**KIRKLEES METROPOLITAN COUNCIL
INVESTMENT & REGENERATION SERVICE**

DELEGATED DECISION TO DETERMINE PLANNING APPLICATIONS

Reference No:	2022/62/93852/W
Site Address:	39, Stile Common Road, Primrose Hill, Huddersfield, HD4 6DE
Description:	Erection of dormer to front and rear and alterations to basement to create dwelling forming annex accommodation associated with 39, Stile Common Road, Primrose Hill, Huddersfield, HD4 6DE
Recommending Officer:	John Holmes

Officer Report – 2022/93852

proposed section AA

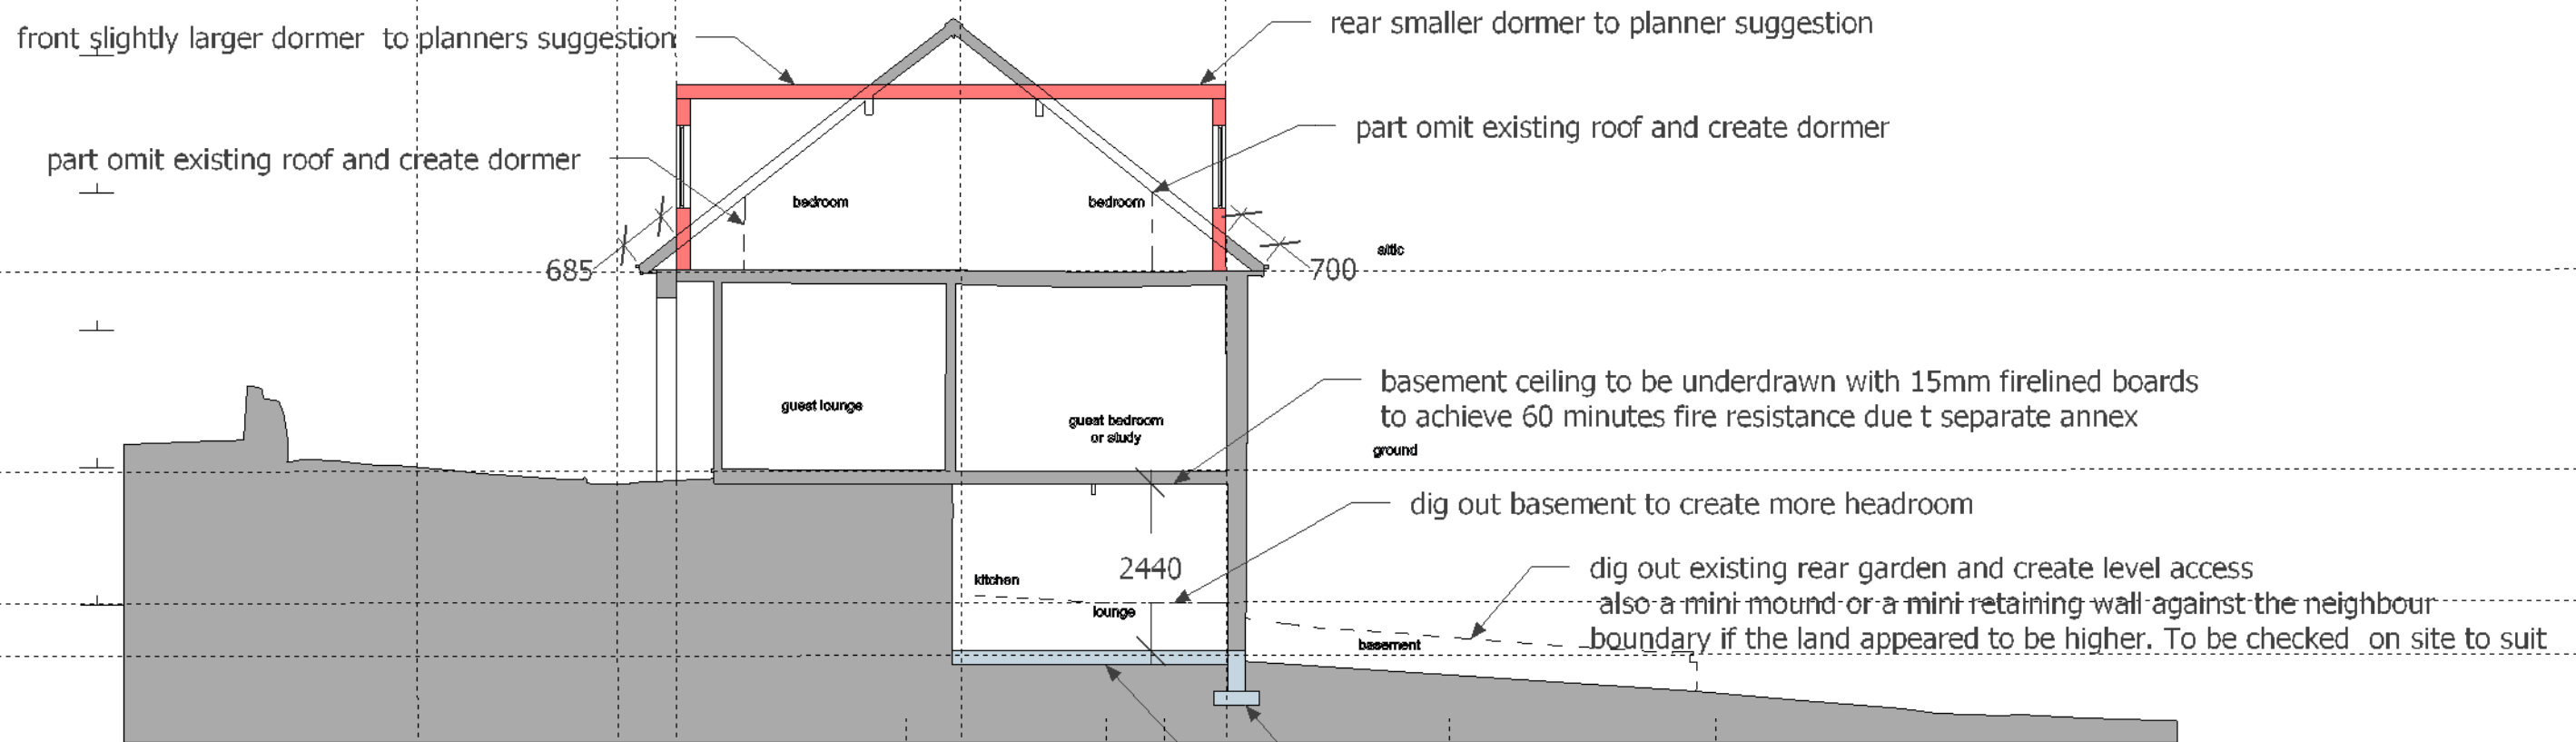
The amended scheme sets out that a small dormer to front would be removed, and replaced by a larger dormer. This dormer would be 3m wide and have height of 2.1m. set back from the eaves by 0.4m and set in by 1.5m at its closest point from the hipped side roofslope and 1.4m from the centre line of the property adjoining no.41. The dormer is of a flat roof design set down from the ridge by 1m.

The dormer to the rear of the host property is 3.8m x 2.2m in size, set back 0.6m and set down 1m, this dormer is set in from the hipped roof slope by 0.3m at its closest point and 1.4m from the shared boundary. The proposal would see this dormer anthracite grey cladding. By contrast, other than a gap of 0.4m from the shared boundary, a dormer fills the entire rear roof slope of the adjoining property (set down 1m and set back from the eaves by 0.7m) and this also wraps around the side of the adjoining property.

The proposed dormer windows have been revised down from that as initially proposed, which sought to replicate that of the adjoining property, which has had dormers which do not harmonise with the character of the host property added.

The proposed dormers would be of a colour finish to match that of the host property, and roof slopes to the front and rear would remain in place. It is considered appropriate to include a condition requiring the dormer cheeks to be of a dark grey colour finish such that they do not contrast with the roof slope to the same degree that white upvc cladding appears to.

3. The front and sides of the dormer windows hereby approved shall be of a dark grey colour finish which shall be retained thereafter.
